Our Case Number: ABP-314597-22

Re: BusConnects Galway Cross-City Link Scheme.
University Road to Dublin Road, Galway City.

RE: Bus connects Galway: Cross-City Link (University Road to Dublin Road) Scheme: 12th September 2022

Role	Transport Infrastructure
Suitability	Planning
Arup Job No	253352-00
Name	BCG-GA-00-03
Rev	PL01

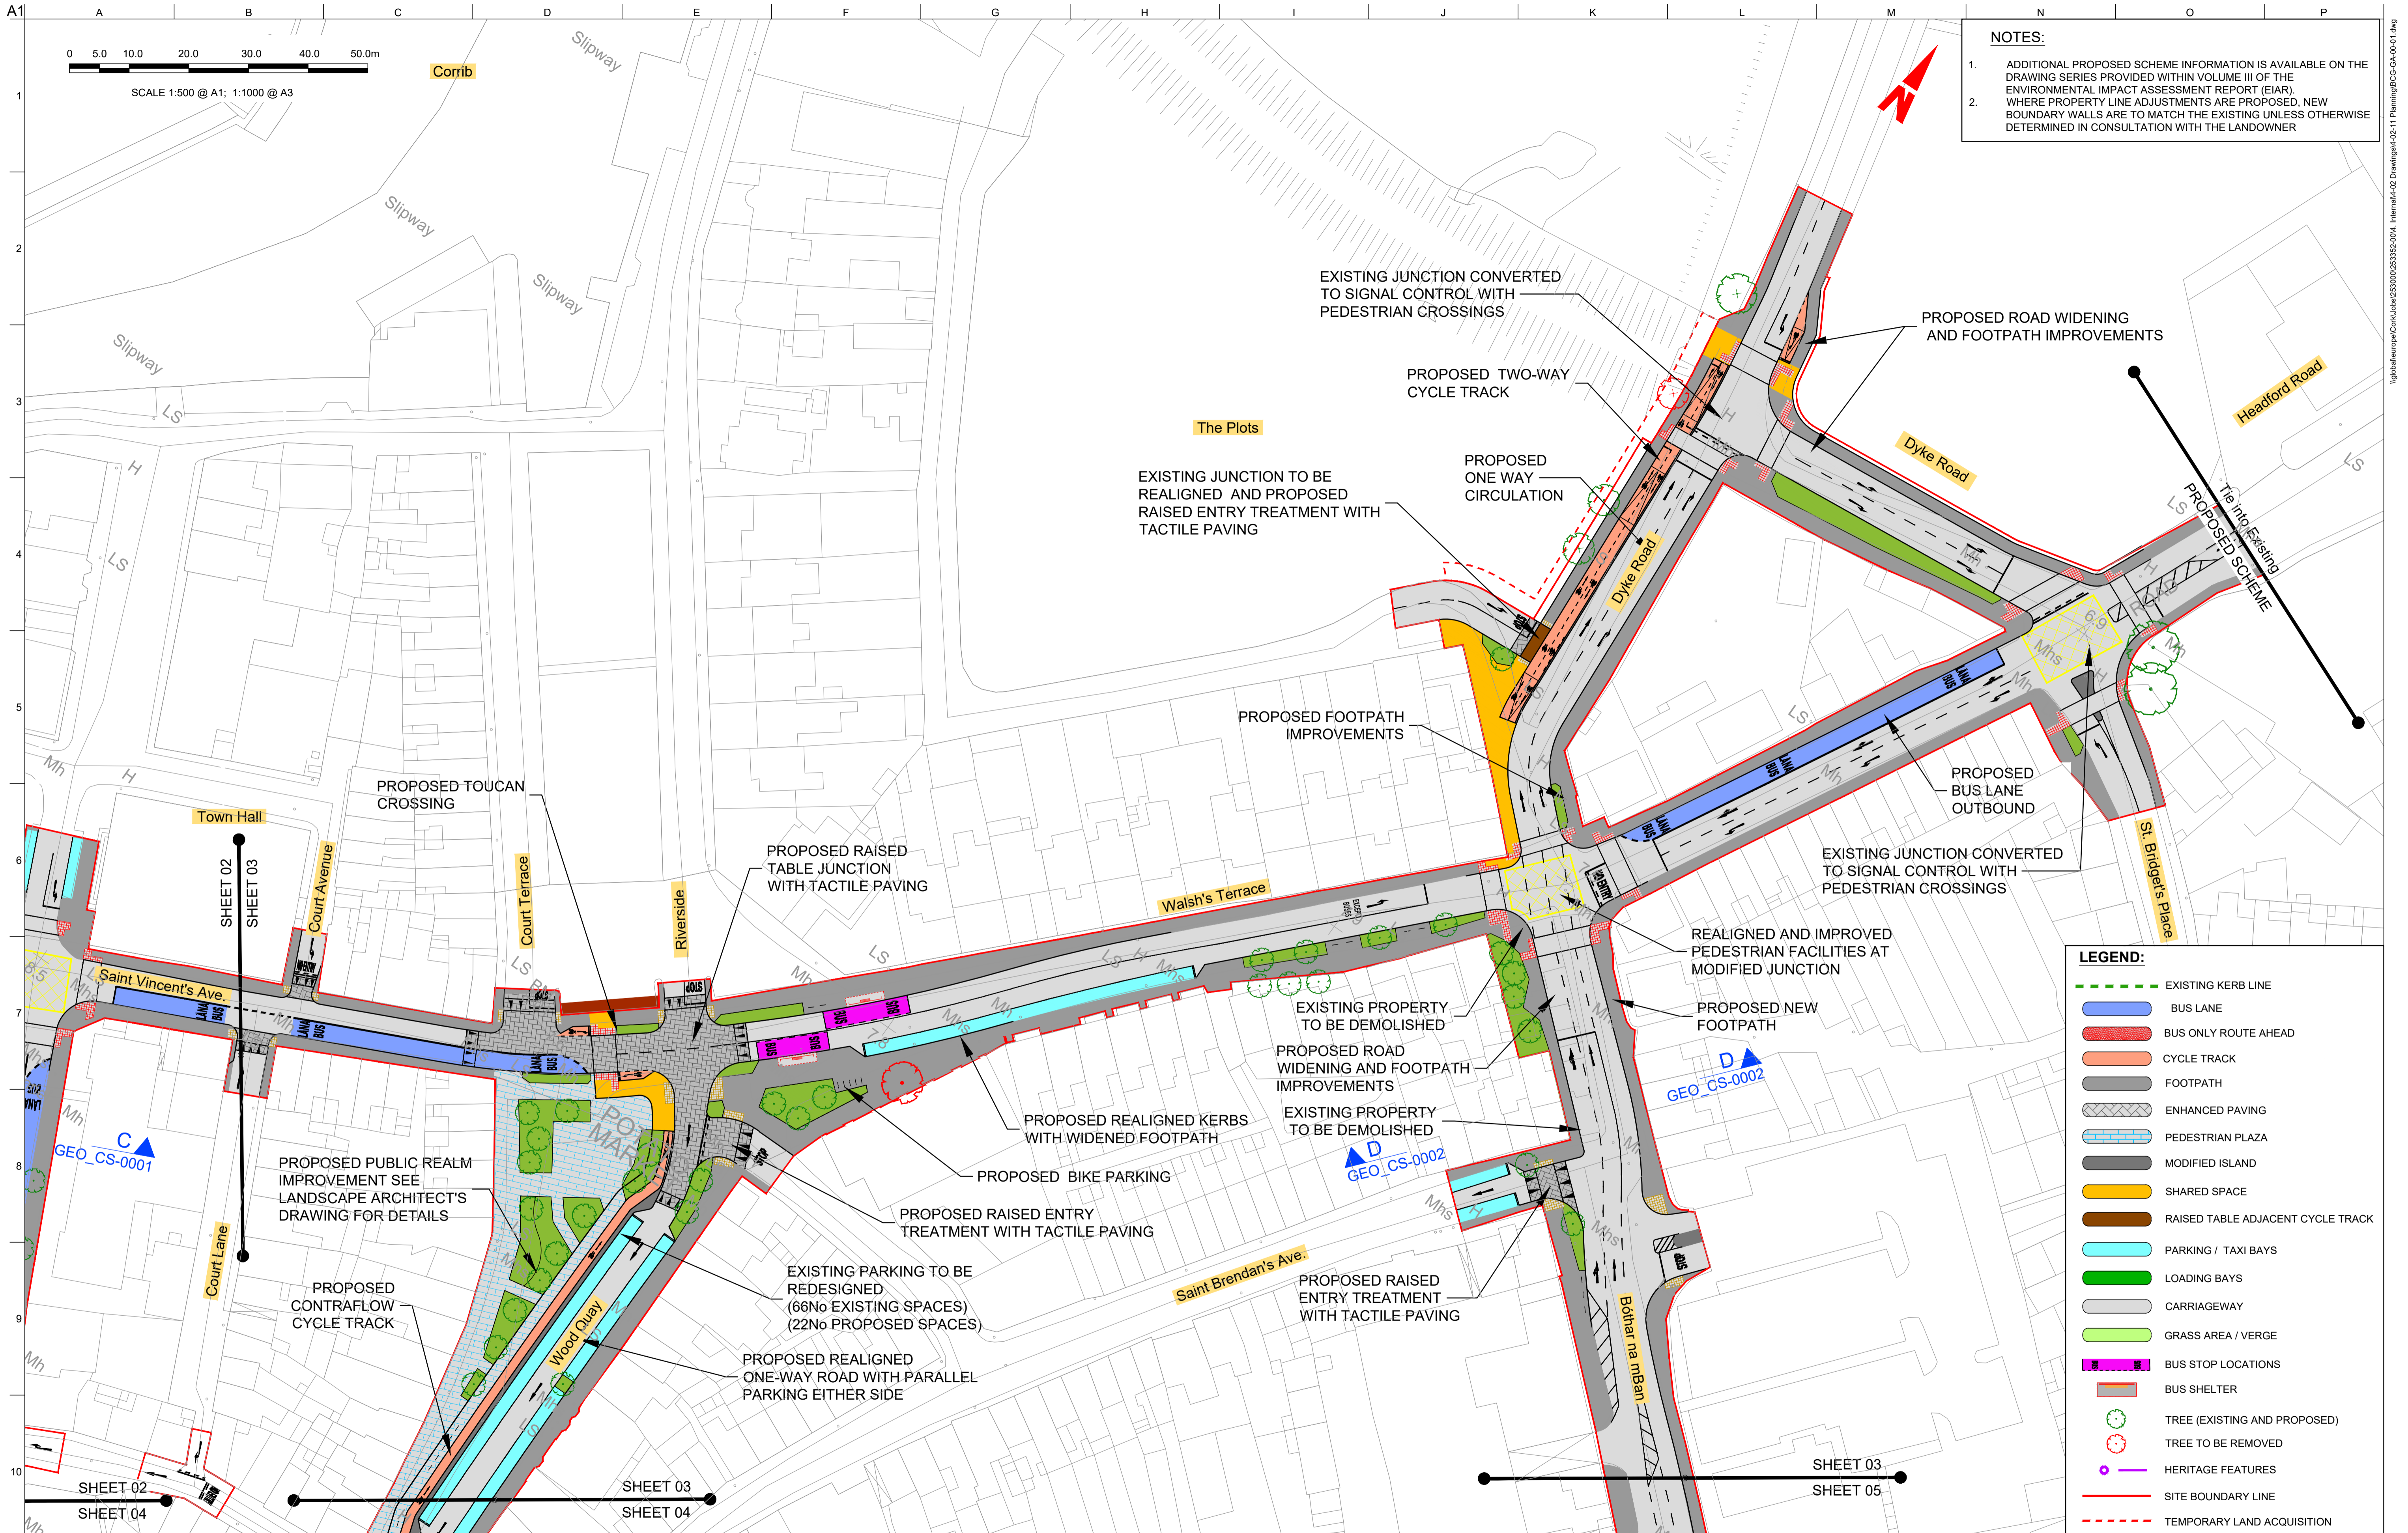
However, looking at the hardcopy of the proposed public transports and cycling / pedestrian's lane of 6.7 kilometres east-west corridor through the city centre we observed an area of concern for the existing taxi rank at Eyre Square, Galway. The diagrams available identify that the current taxi rank will be axed during and after the road project.

Therefore, we stand unanimously to object the likely removal of the taxi rank in Eyre Square.

Thanking you in-anticipation of a reversal and amendment to the route to accommodate the smoot running of our taxi business.
